Our Ref: P/67/22/NMA

Non-material amendment following grant of P/172/21/HH for the dormer on the south elevation to extend to rear of building.

16 Cardinals Drive Pagham PO21 4QF

REV. A. MAR. 22'.
DORMER TO S.E.
EXTENDED TO REAR.

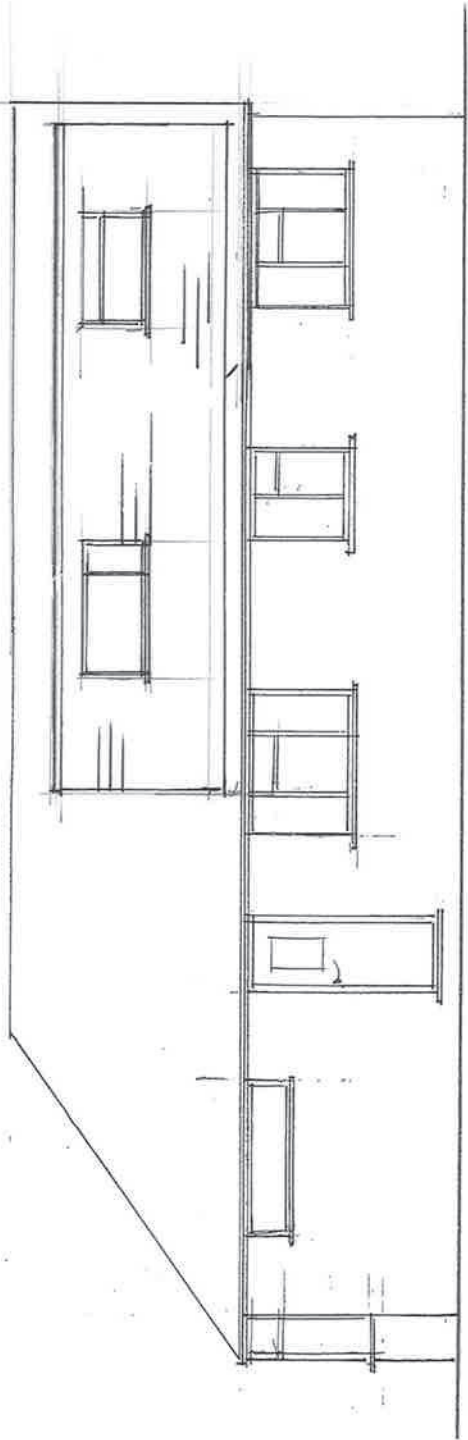
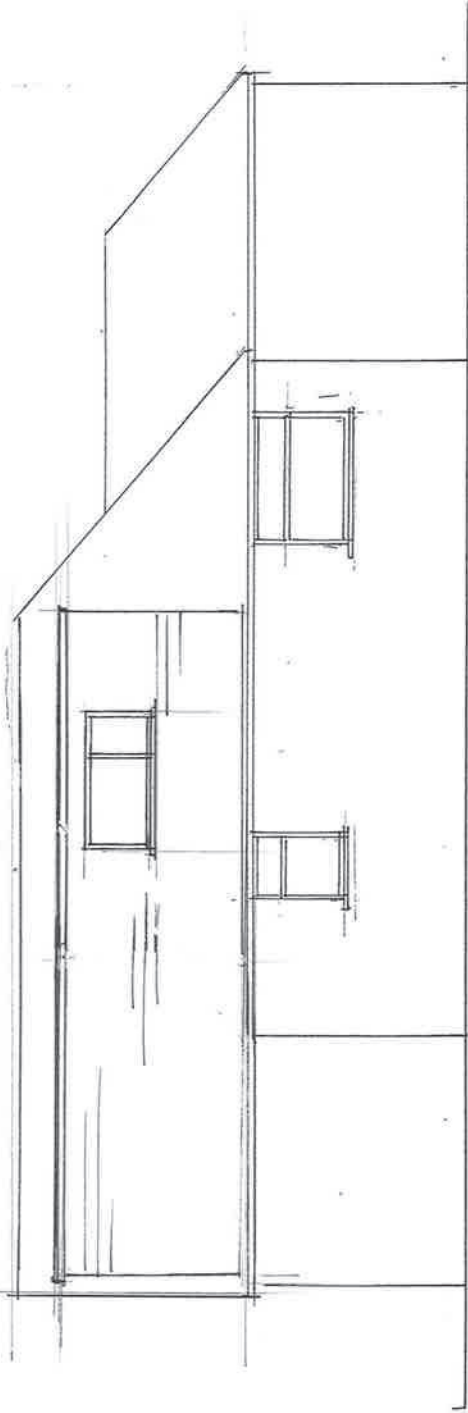
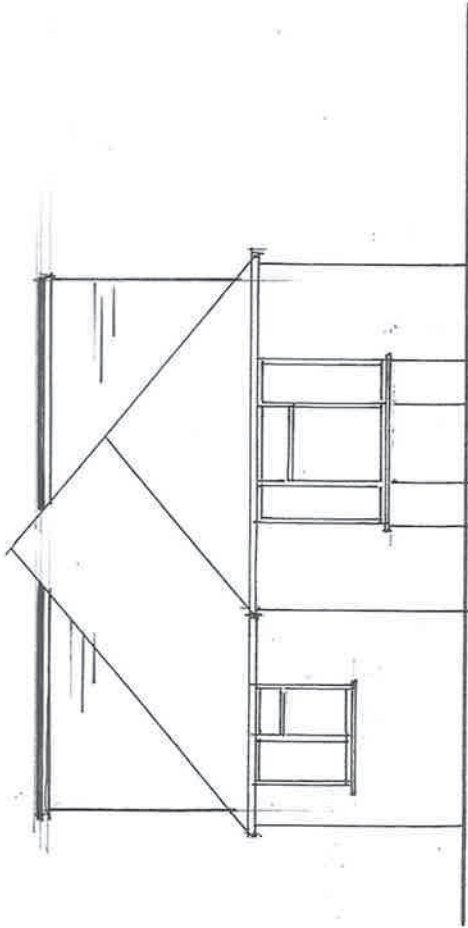
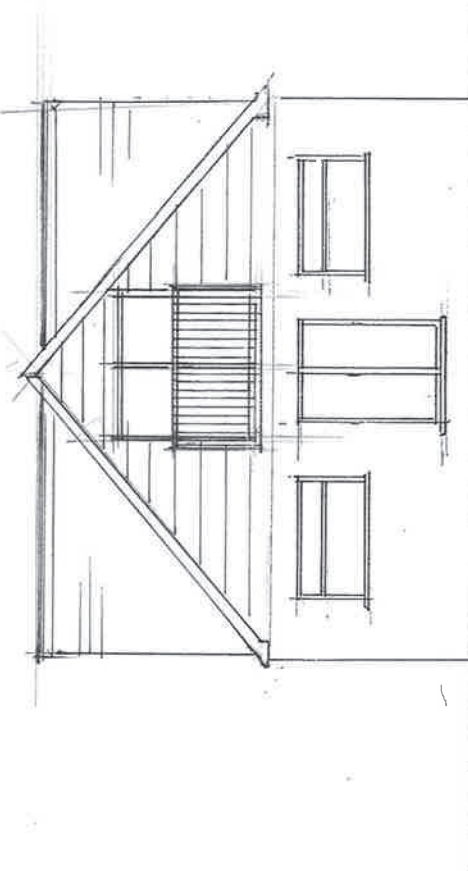
The reasons that these proposals have not been accepted as Non-Material Amendments is because the extension to the dormer will materially alter the appearance of the building, and extends it beyond the recommended criteria, and it cannot therefore be considered under section 96A of the Town and Country Planning Act 1990.

From the information submitted I am not able to take the alterations as a Minor Amendment to P/172/21/HH.
